HANNAH RIDGE AT FEATHERGRASS FILING NO. 6

A REPLAT OF TRACT KK OF HANNAH RIDGE AT FEATHERGRASS FILING NO. 1, RECEPTION NO. 214713468, RECORDS OF EL PASO COUNTY, COLORADO SECTION 32, TOWNSHIP 13 SOUTH, RANGE 65 TY, COLORADO WEST OF THE SIXTH PRINCIPAL MERIDIAN, EL PASO COUNTY, COLORADO

SF-18-039

HANNAH RIDGE AT FEATHERGRASS FILING NO. 6

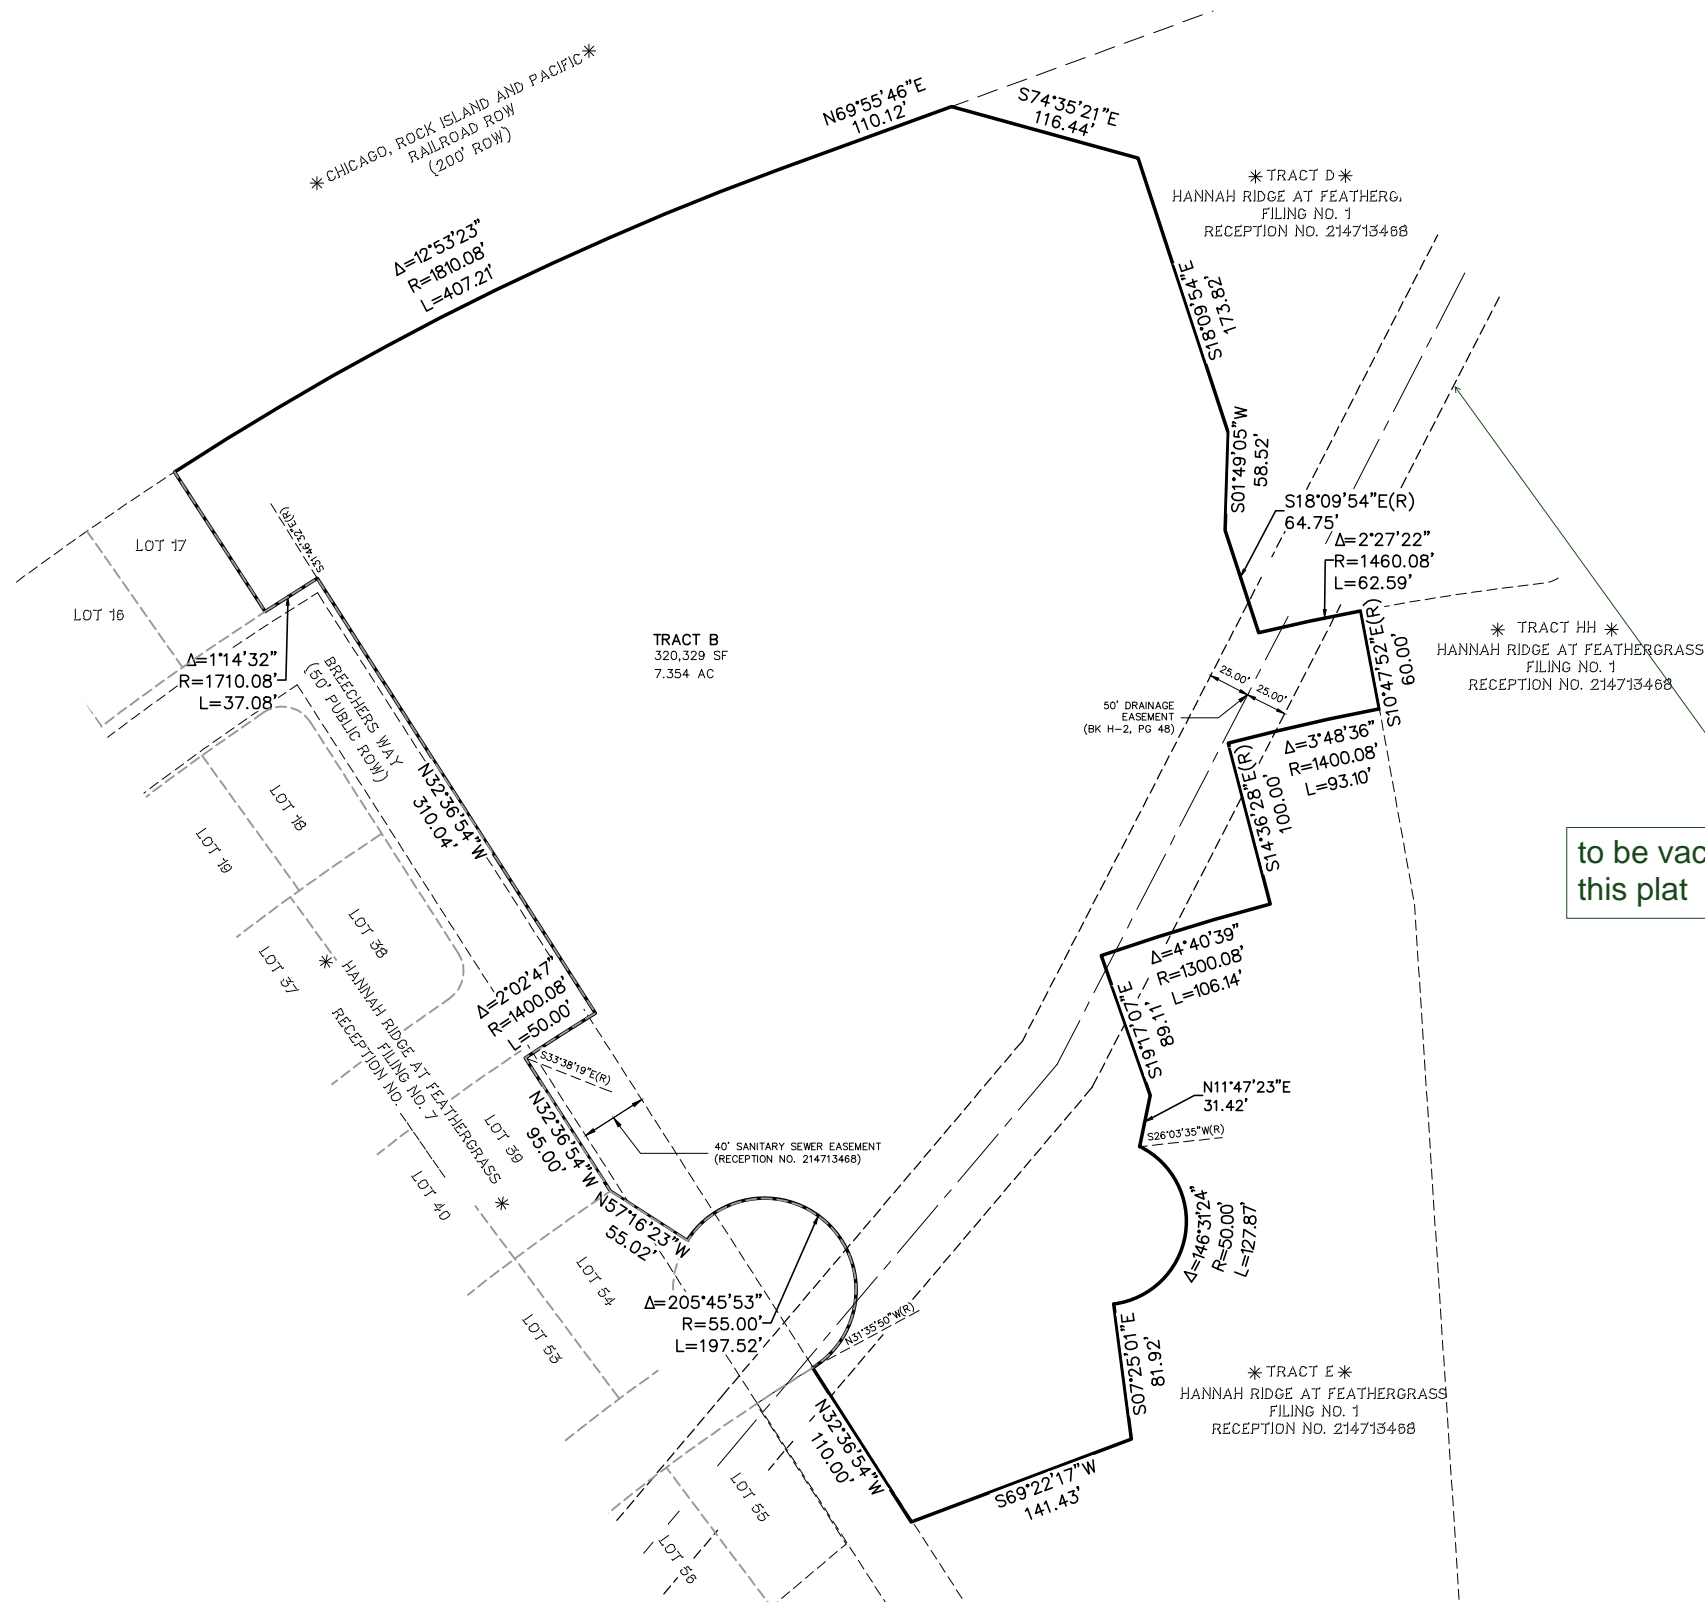
define the outer subdivision line boundary with a thicker or different line type. It is difficult to delineate from lot lines
